**RE: DRAINAGE PLAN FOR DAHL INC. (H15-D7A) REVISION DATED
11/21/96.**

DRAINAGE INFORMATION SHEET

PROJECT TITLE: DAHL INC ZONE ATLAS/DRNG. FILE #: H15/H7A

GRADING AND DRAINAGE PLAN DAHL, INC.

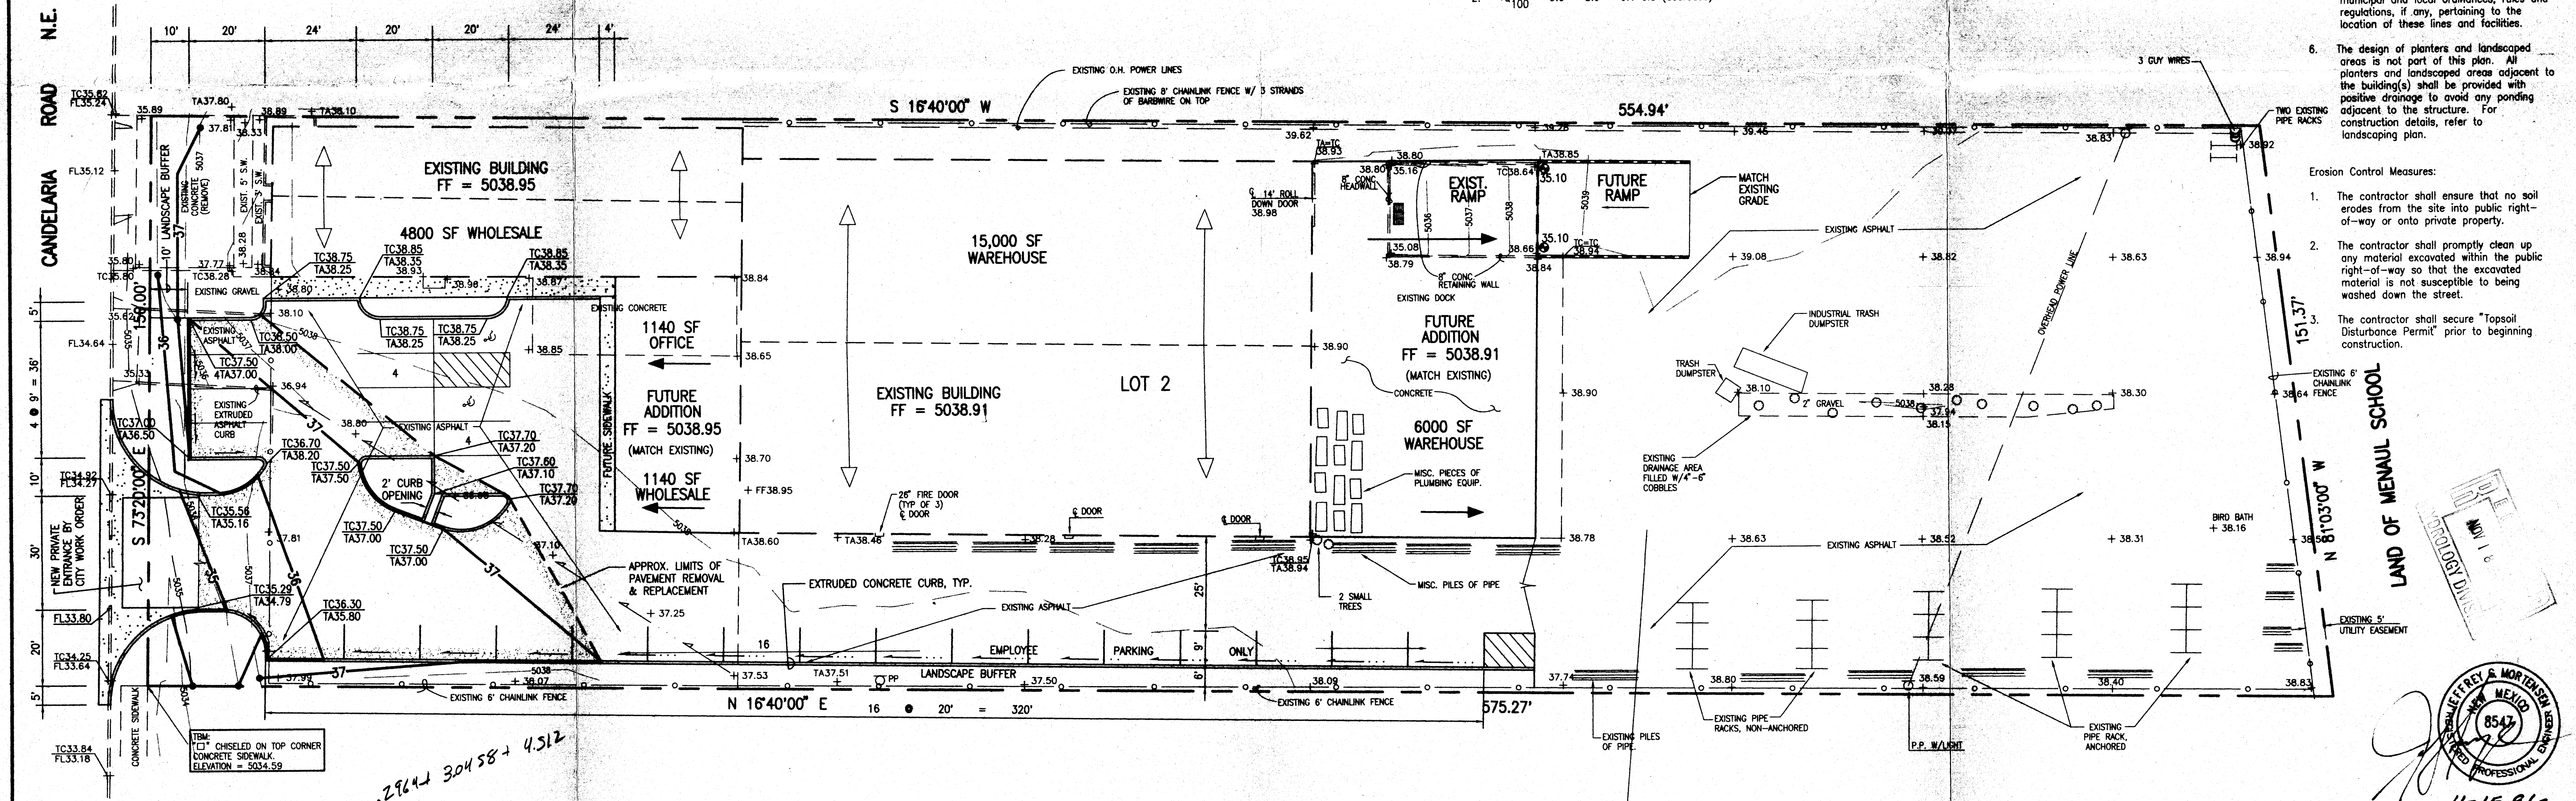
Comparison 9.0-7.5 instead of 9.0-8.5
